Item No. **Report of the Head of Planning, Transportation and Regeneration**

Address 39 SOUTHCOTE RISE RUISLIP

Development: Erection of single and two storey extension to the side following removal of two side chimneys, and single storey extension to the rear.

LBH Ref Nos: **77055/APP/2022/442**

| rev: | date: | description: |
|-------------|--|---|
| drawing no: | 1094 / P / 2 | drawn: AF |

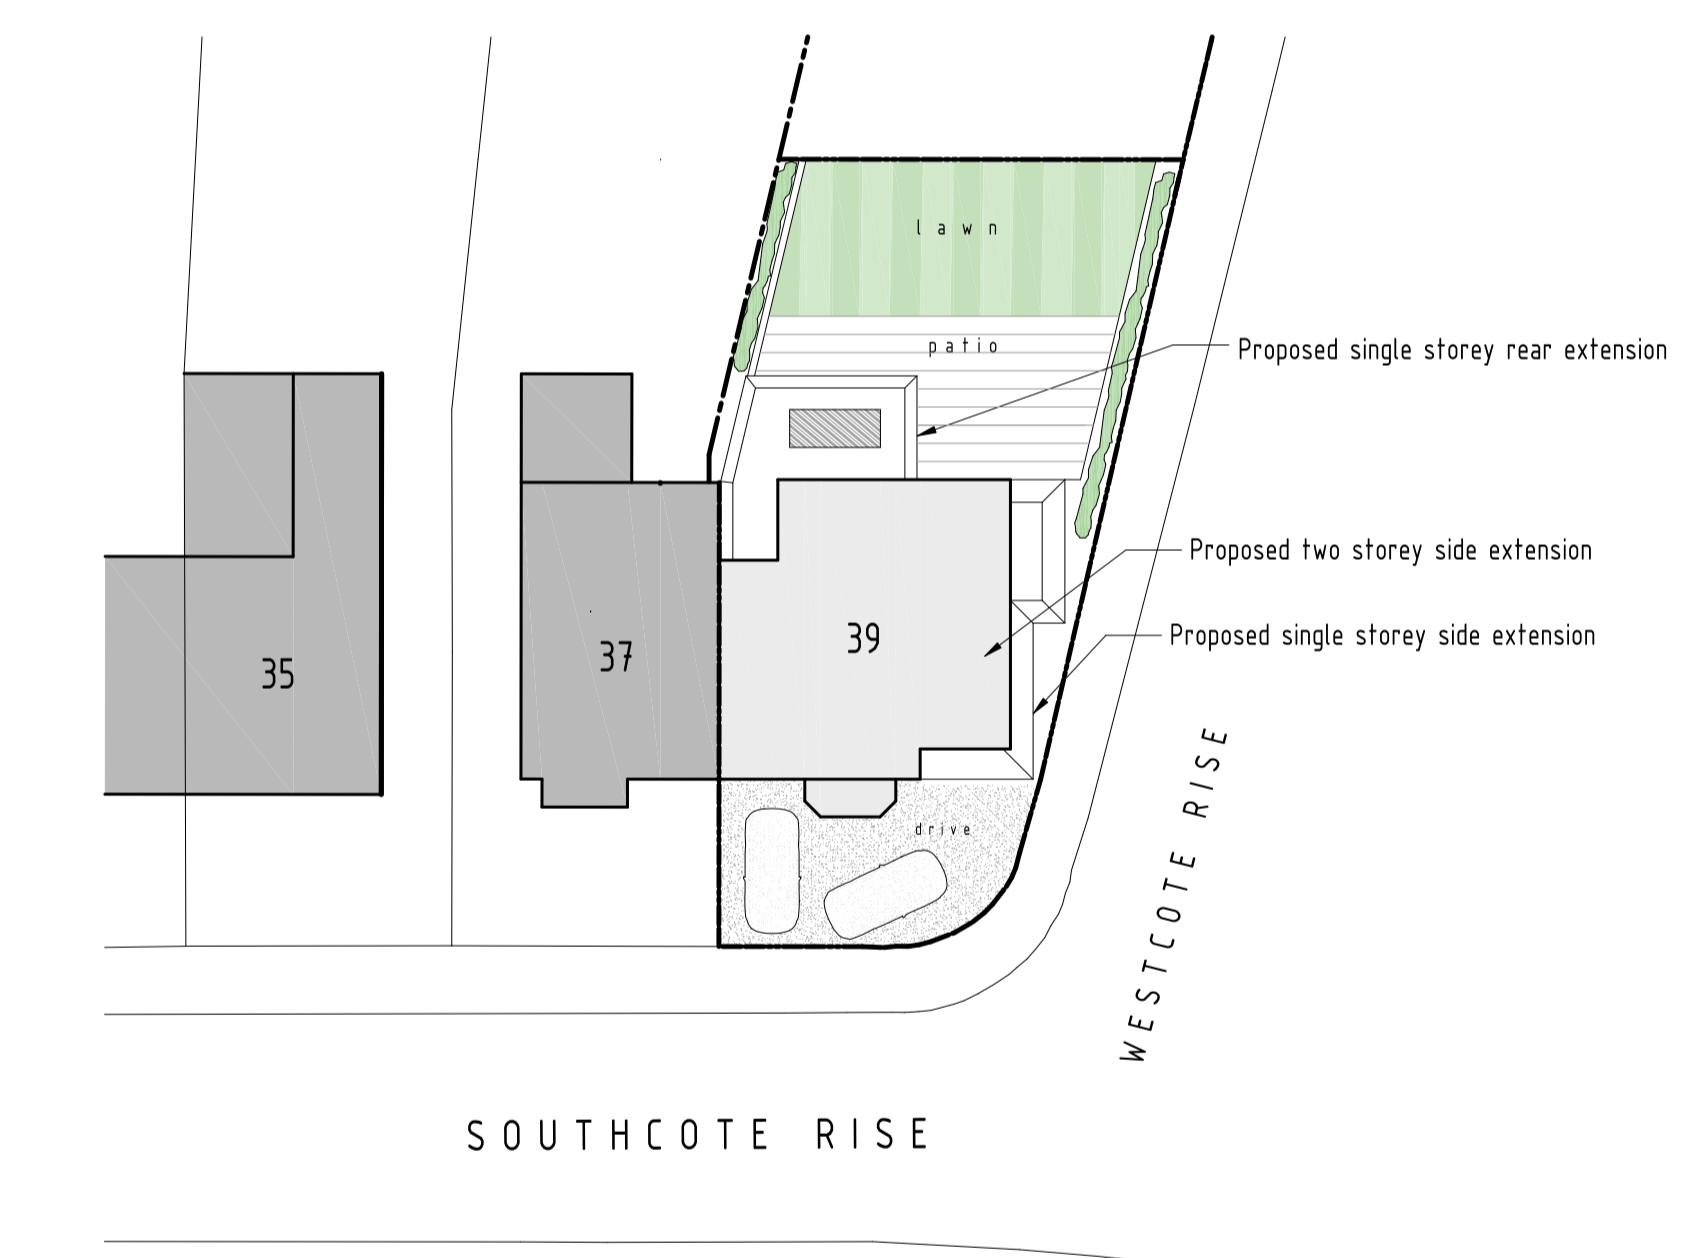
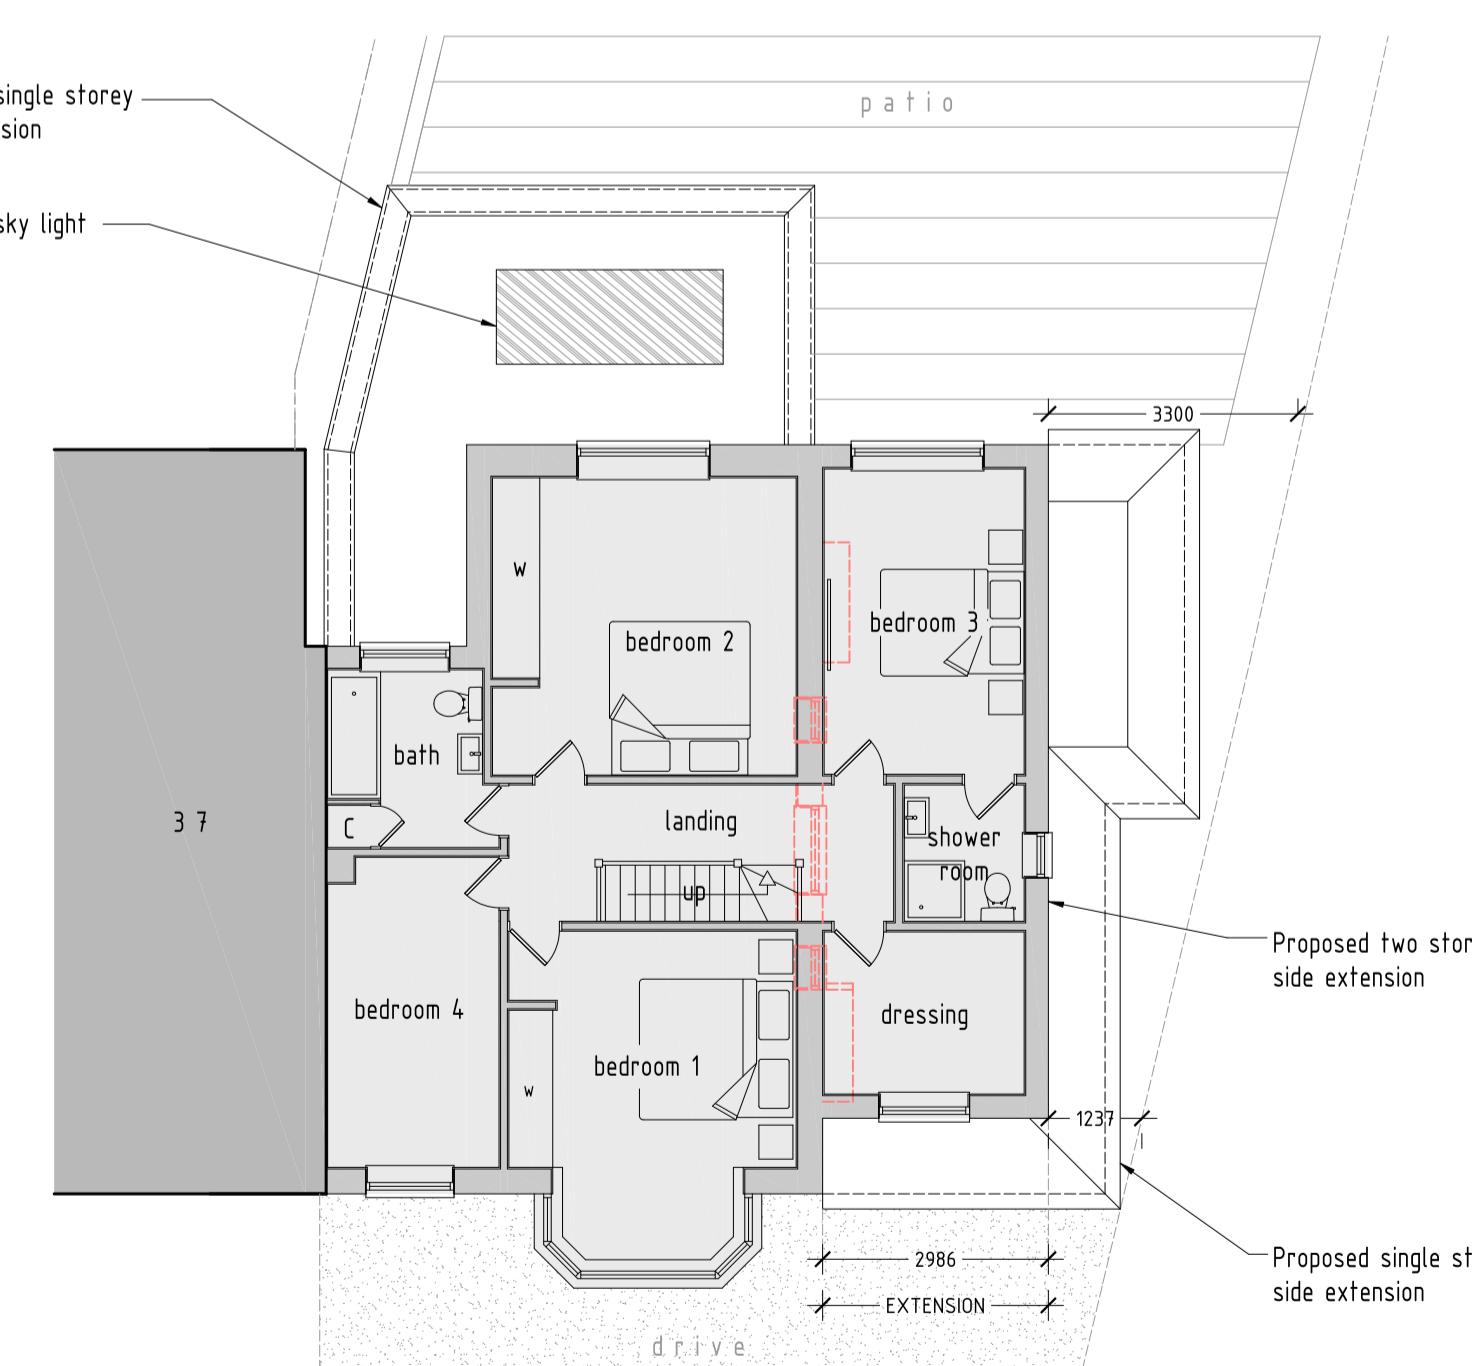
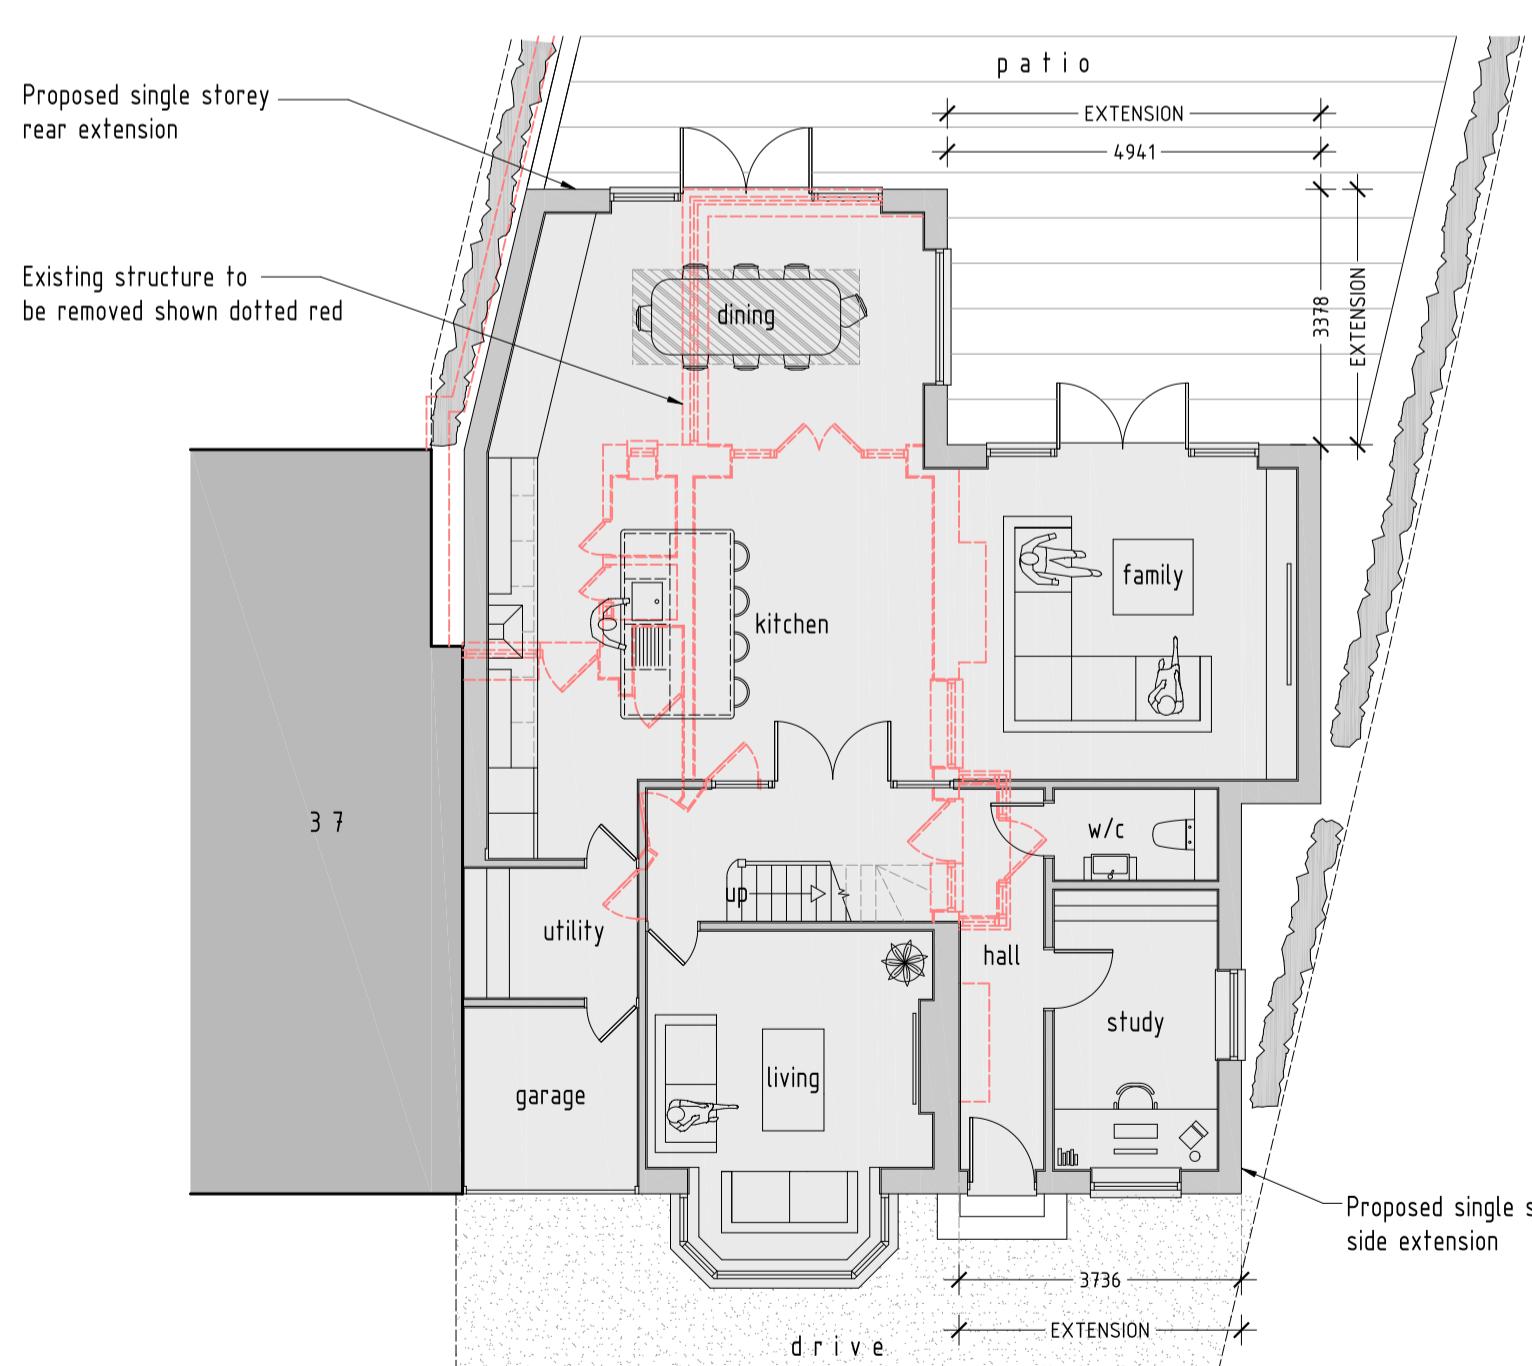
The existing rear conservatory would be removed and a 3.38metres deep single storey rear extension is proposed that would be sited 40cm gap to the shared boundary with No.37. Hedging and 2metre high fencing along the shared boundary would partially screen the single storey rear extension which is 2.6metres in height. The single storey rear extension is considered to broadly accord with the aims of Policies DMHB 11 and DMHD1.

The two storey side extension would be not be set back from the front elevation and would have a maximum width of 4.94metres and extend the length of the dwelling to finish flush with the existing rear elevation. The first floor element would however be set back from the front elevation and to the side. It would be characterised with a large side crown roof set down from the main ridge, which is at odds with the hipped roof of the original dwelling.

The original dwelling is noted to have a width of 6.55metres whereas the extended dwelling would be 11.3metres wide. The proposal would therefore far exceeding half the width of the existing dwelling as set out in Policy DMHD1. The side extension incorporates a single storey wrap-around on the front and side elevation with a hipped roof requiring removal of the two prominent chimneys on the east elevation. The roof of the two storey side/rear extension would be set down from the main ridge. However the proposal would only retain a small gap 40cm gap to the boundary with Westcote Rise where the side elevation would be particularly prominent in the street scene.

The site is on a corner plot and the extension would be very prominent when viewed from the street, in particular, on the approach from Westcote Rise, where the front, side and rear of the property are very conspicuous. The side extension would be positioned 40cm from the boundary with the pavement. Whilst the two storey side extension is set back at first floor level from the front and side elevation, the length of the proposal would stretch a considerable distance along the road and would thus appear as a visually dominant and intrusive feature in the street-scene and would detract from the sense of open space that exists between the dwelling and the highway.

The visual impact of the side extension is further exacerbated by its awkward and out of character crown roof. The development would appear insubordinate, visually incongruous and would fail to harmonise with the architectural composition of the original dwelling. As such, it is considered that the development would fail to maintain the character and appearance of the dwelling, resulting in a negative impact on the visual amenities of the site and the surrounding area.

The development proposal, by reason of its size, scale, height, depth, roof form and design, would result in a bulky, insubordinate, incongruous, dominant, and cramped form of development in this visually prominent location that would fail to harmonise with the architectural composition of the original dwelling, and in this open prominent position, would result in the closing of an important gap characteristic to the area, to the detriment of the character, appearance and visual amenities of the street scene and surrounding area. For these reasons, the development proposal would conflict with Policy BE1 of the Hillingdon Local Plan: Part One Strategic Policies (2012) and Policies DMHB 11, DMHB 12 and DMHD 1 of the Hillingdon Local Plan: Part Two - Development Management Policies (2020), Policy D3 of the London Plan (2021) and Section 12 of the National Planning Policy Framework (2021)
